A47 North Tuddenham to Easton Dualling

9.26 Non-Material DCO Changes Request

NON-MATERIAL DCO CHANGES REQUEST

Rule Number:	Rule 8
Planning Inspectorate Scheme Reference	TR010038
Application Document Reference	TR010038/EXAM/9.26
BIM Document Reference	HE551489-GTY-LSI-000-RP-TX-40018
Author:	A47 North Tuddenham to Easton Project Team, Highways England

FILE# 1469-GIT-ESF-000-DK-GIT-5500Z

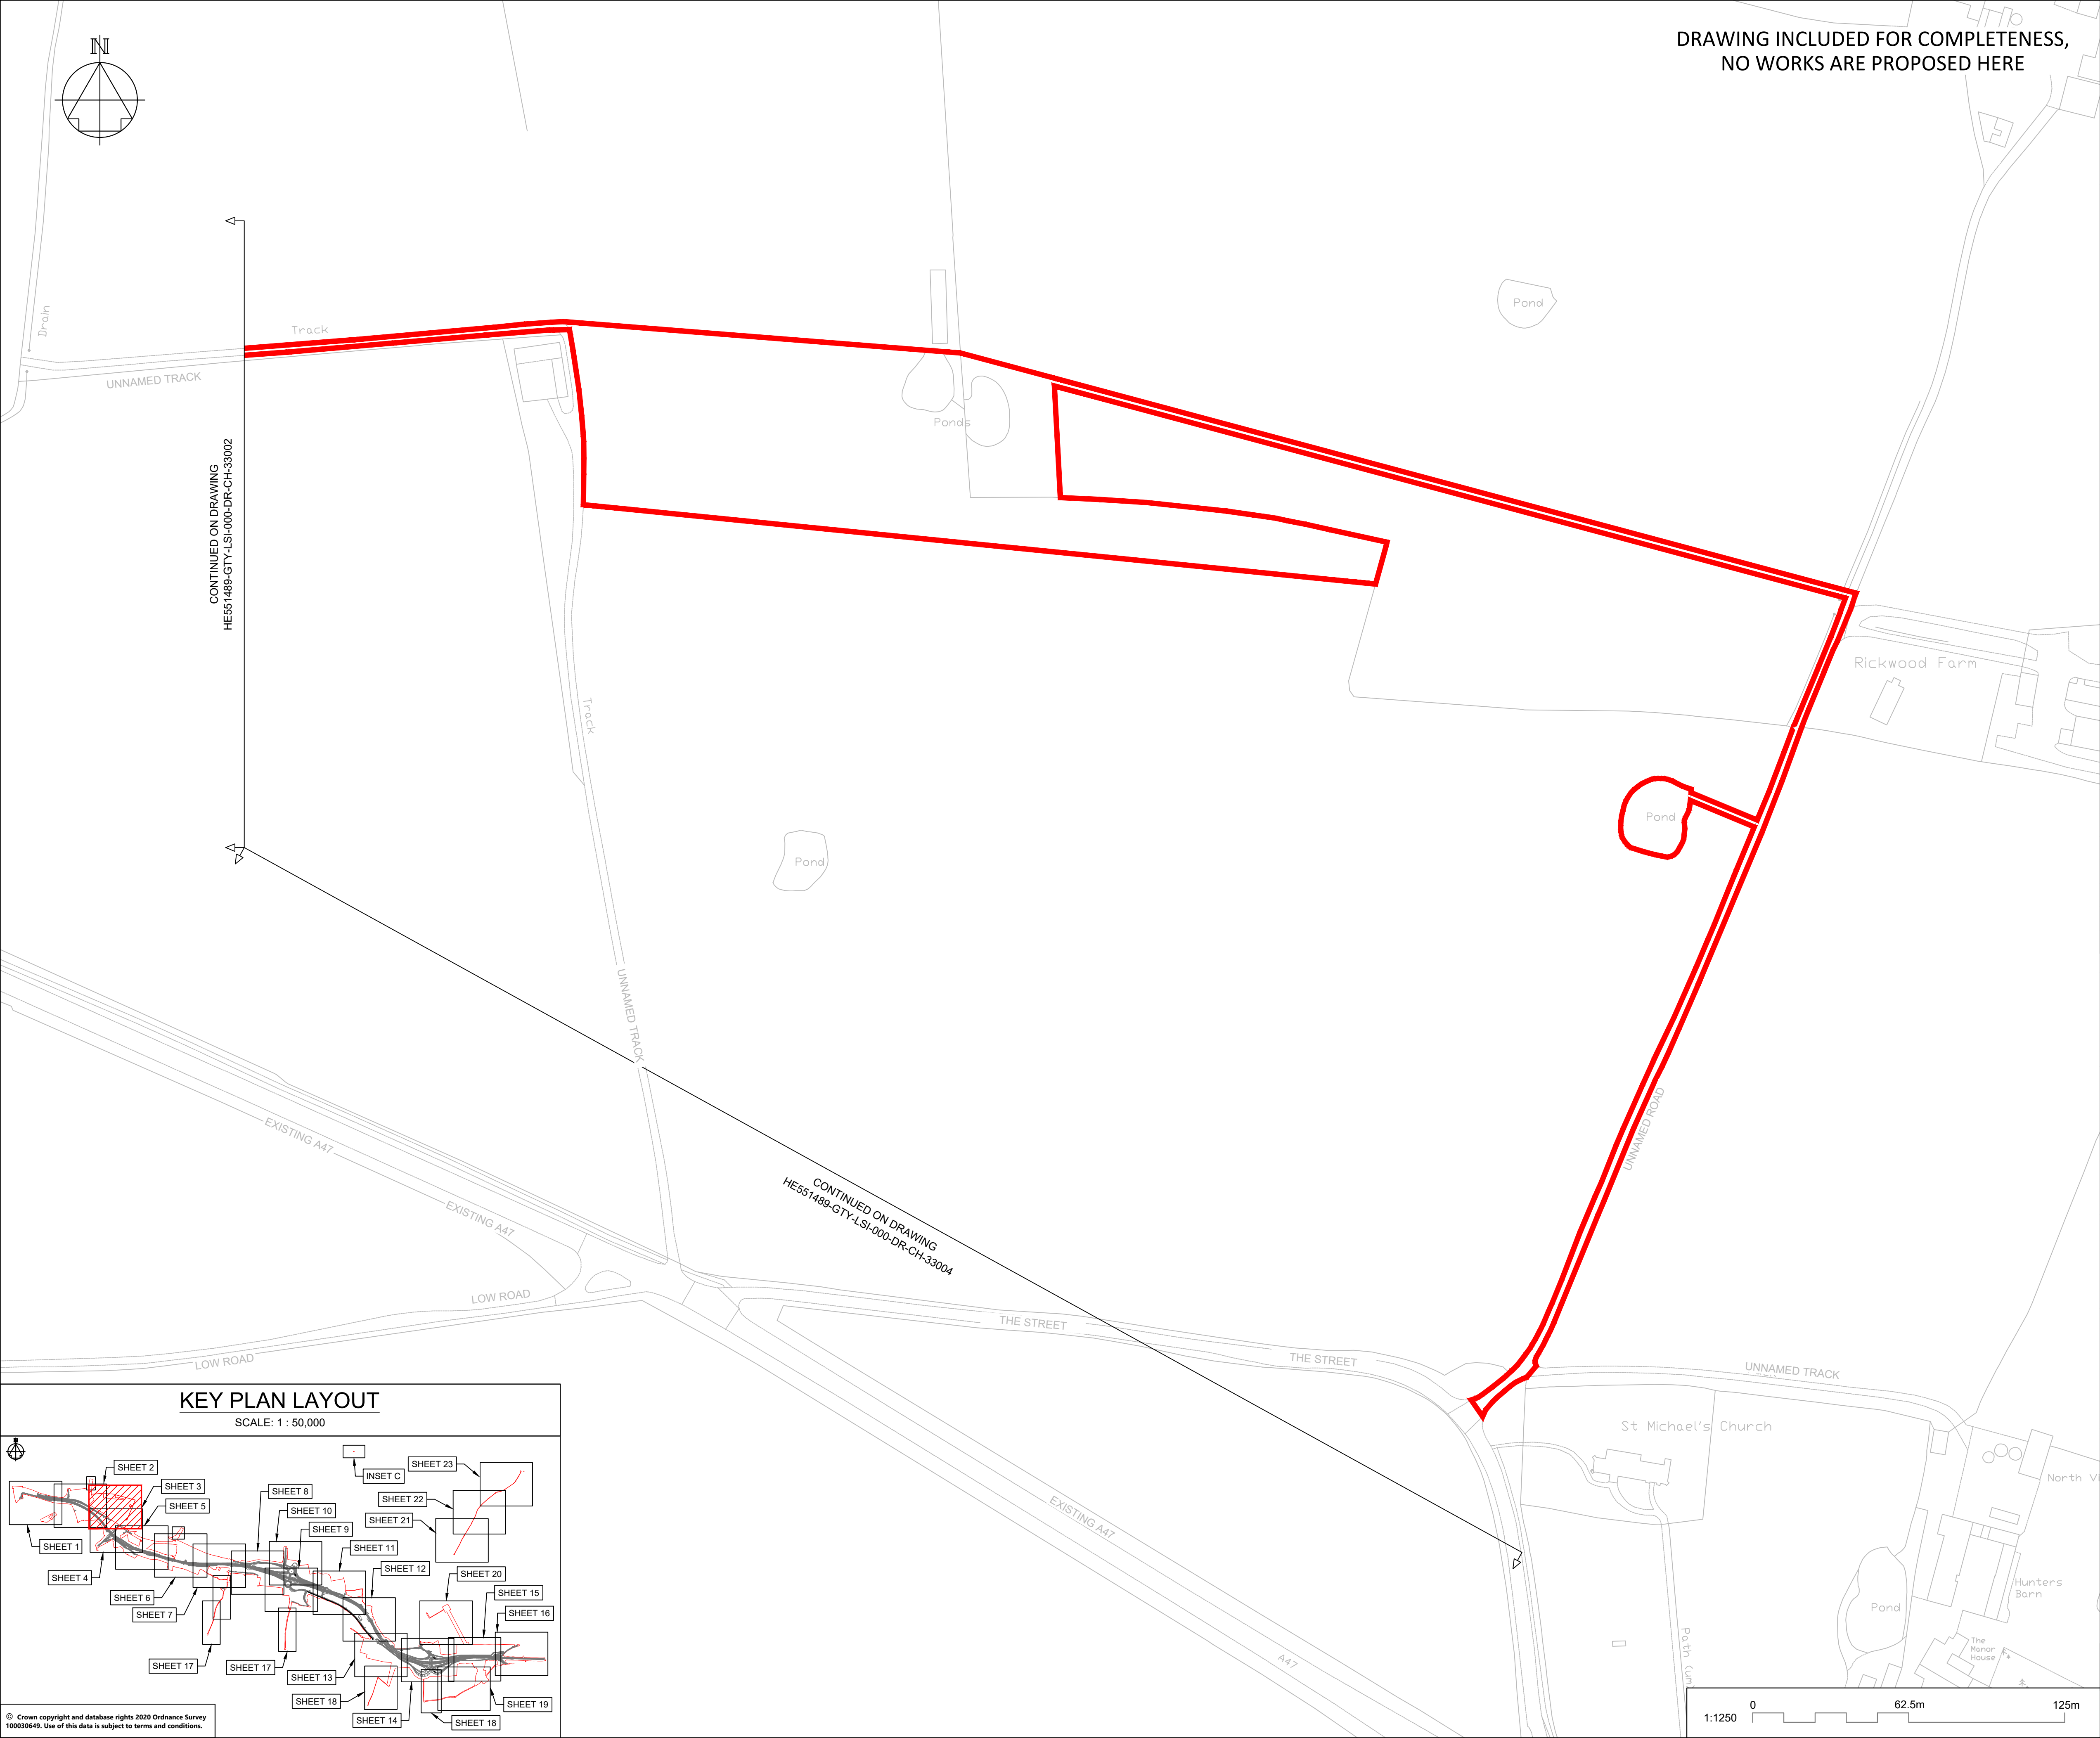
- 2.5.1 This design change involves moving the access point at the drainage basin on Lyng Road, south of the existing A47 (dDCO Work No. 6), to provide a shared turning area beside the Vodafone mast across Lyng Road opposite the drainage basin.
- 2.5.2 This design change is illustrated in Figure 2.2 below and Sheet 4 of the DCO plans listed in Table 2.2 has been updated to show this change in the design.
- 2.5.3 This design change does not result in any additional permanent land take as it is just a re-arrangement within the permanent landtake for this drainage basin.

- 3.4.1 Moving the access point at the drainage basin on Lyng Road (dDCO Work No. 6) is required to provide a shared turning area beside the existing Vodafone mast across Lyng Road opposite the drainage basin.

- 3.4.2 During engagement with the mobile phone operator it has been identified that the current maintenance access arrangement involves a vehicle accessing Lyng Road from the existing A47 via Oak Farm. This enables the vehicle to travel one-way along Lyng Road to exit at Low Road. With the severance of access on the A47 and no existing agreement to turn vehicles within private land off Oak Farm, the Applicant proposed adapting the drainage basin access to provide a shared turning area beside their mast.

HE551489-GTY-LSI-000-DR-CH-33006

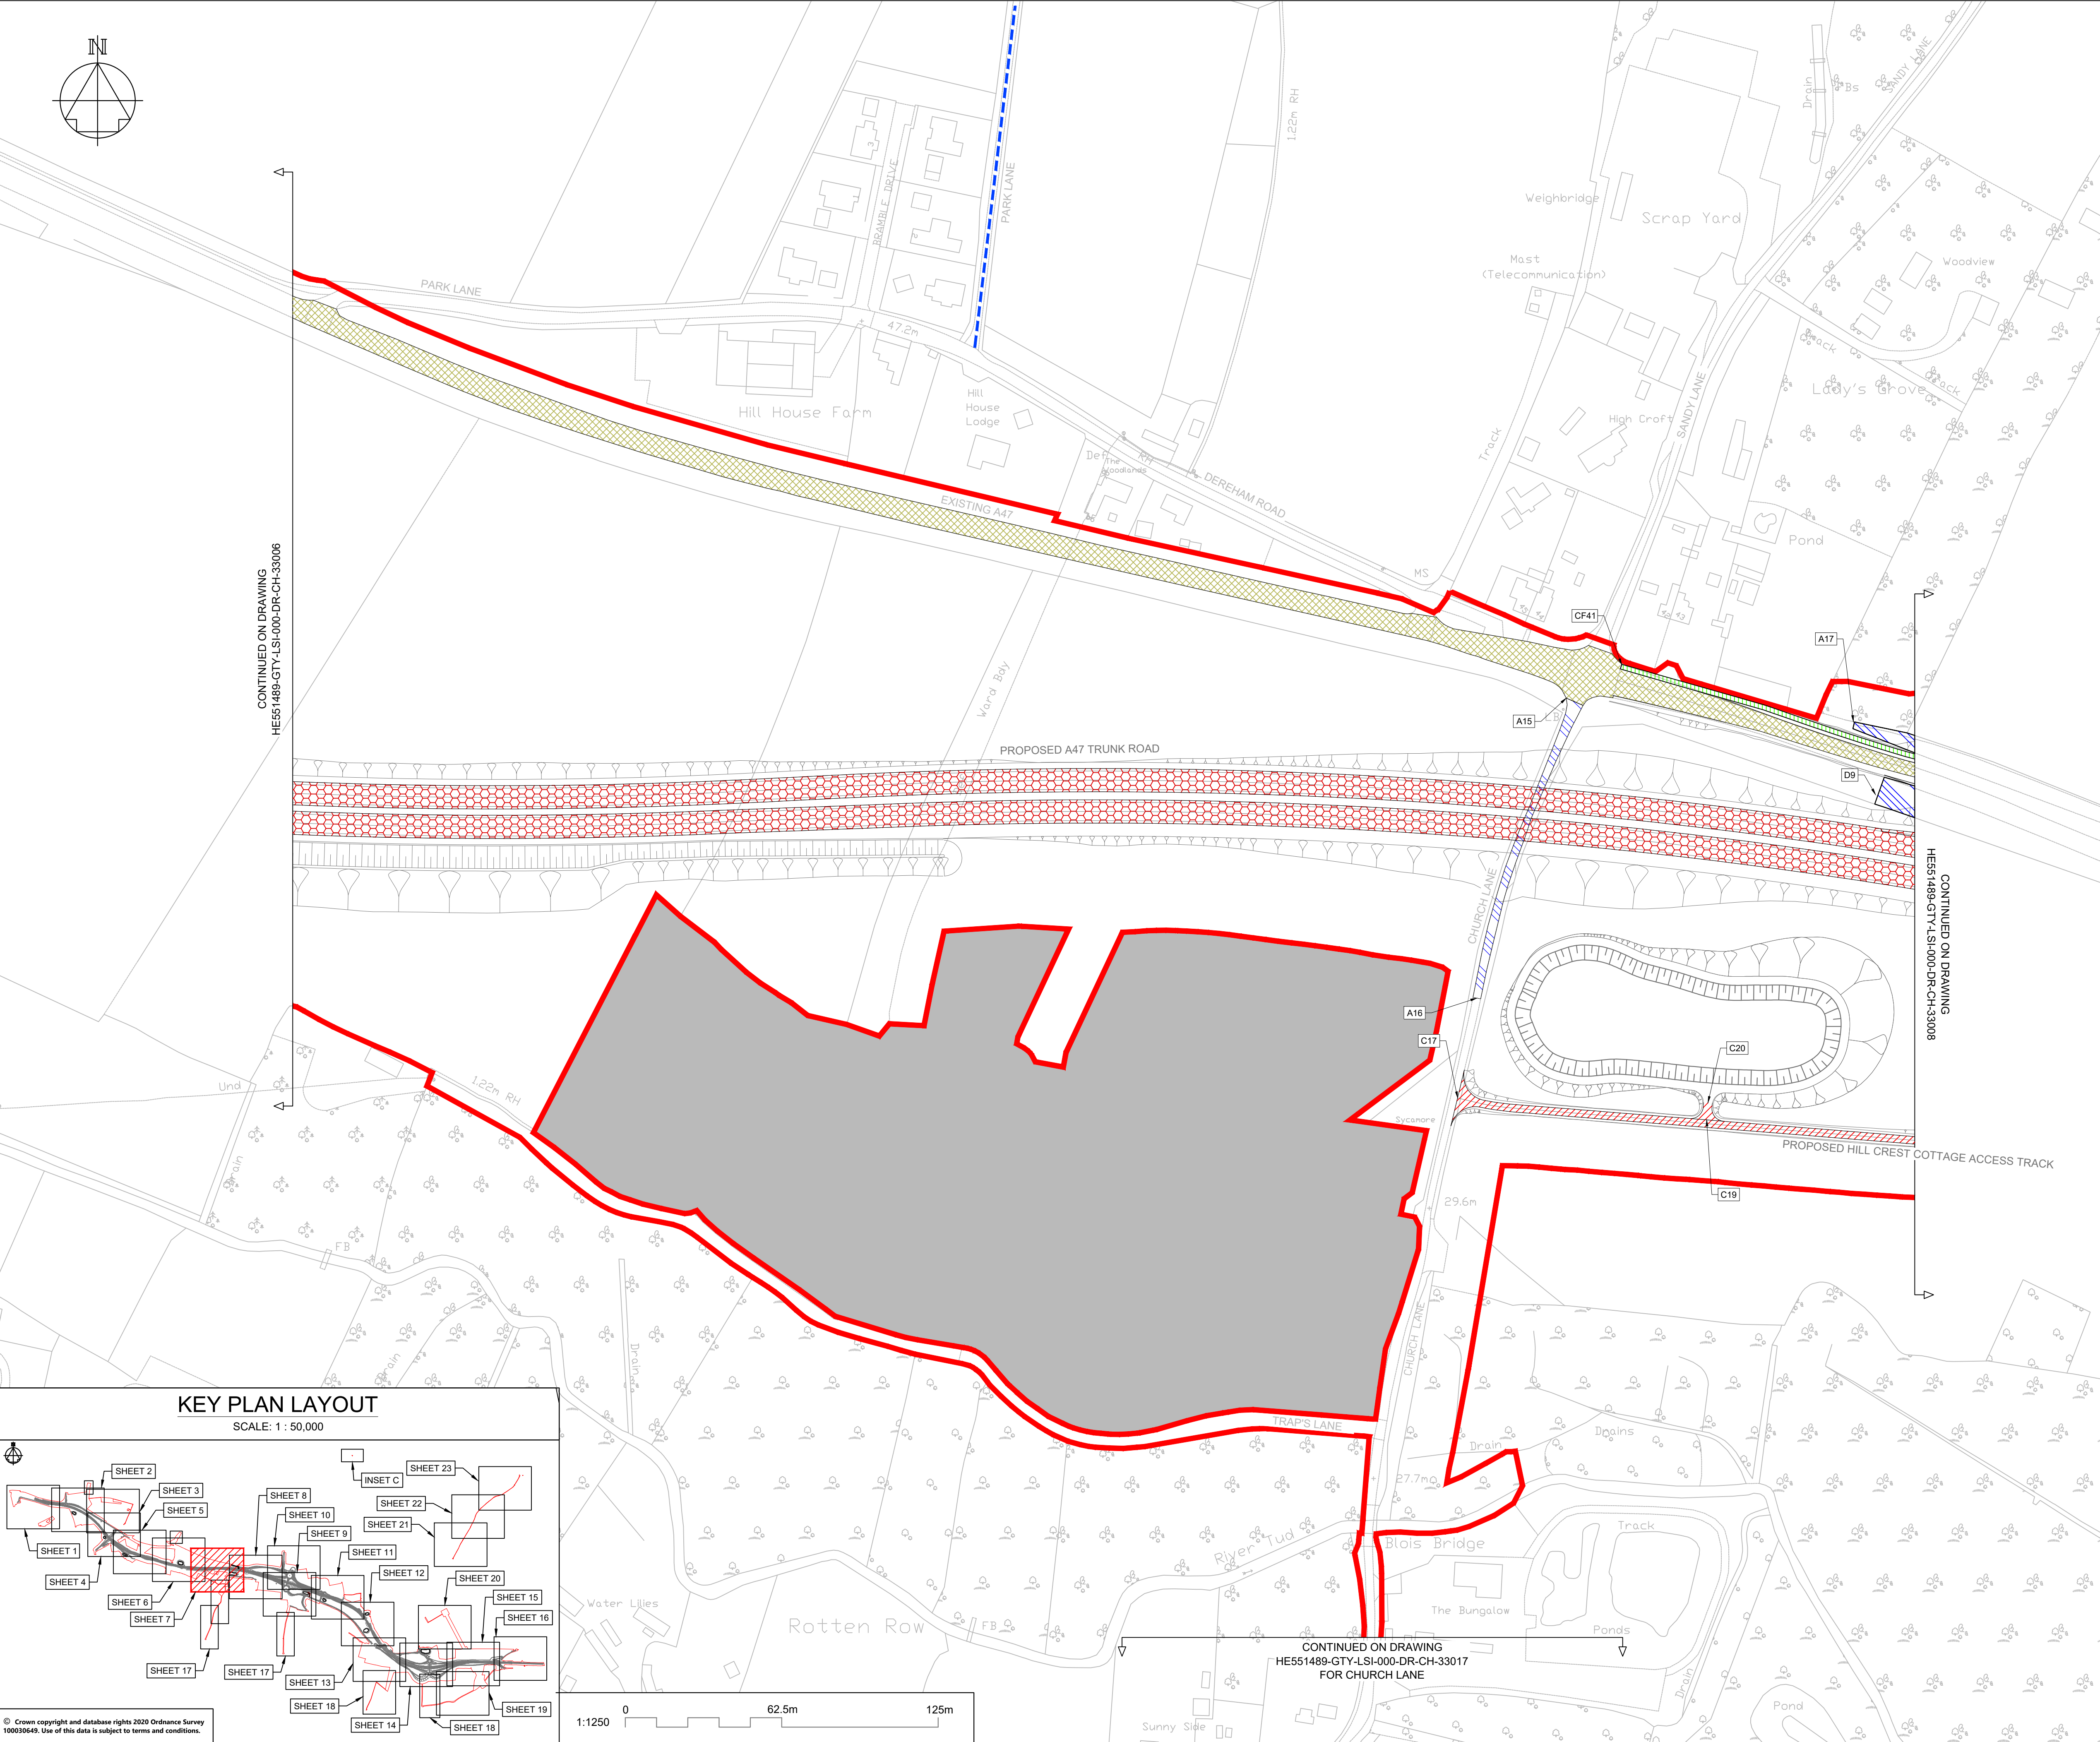
- 2.2.1 This design change involves the addition of a ghost island for turning right into the new Mattishall Lane Link Road from the existing A47. The current junction design has been widened with road markings used to facilitate turning in and out of Mattishall Lane from the existing A47. The highways limits of deviation have been adjusted accordingly.

- 2.2.2 This design change is illustrated in Figure 2.1 below and Sheet 4 of the DCO plans listed in Table 2.1 has been updated to show this change in the design.

- 3.1.2 This provision will afford vehicles turning right onto Mattishall Lane Link Road further protection, improving road user safety and assist with the free flow of road traffic on the de-trunked A47.
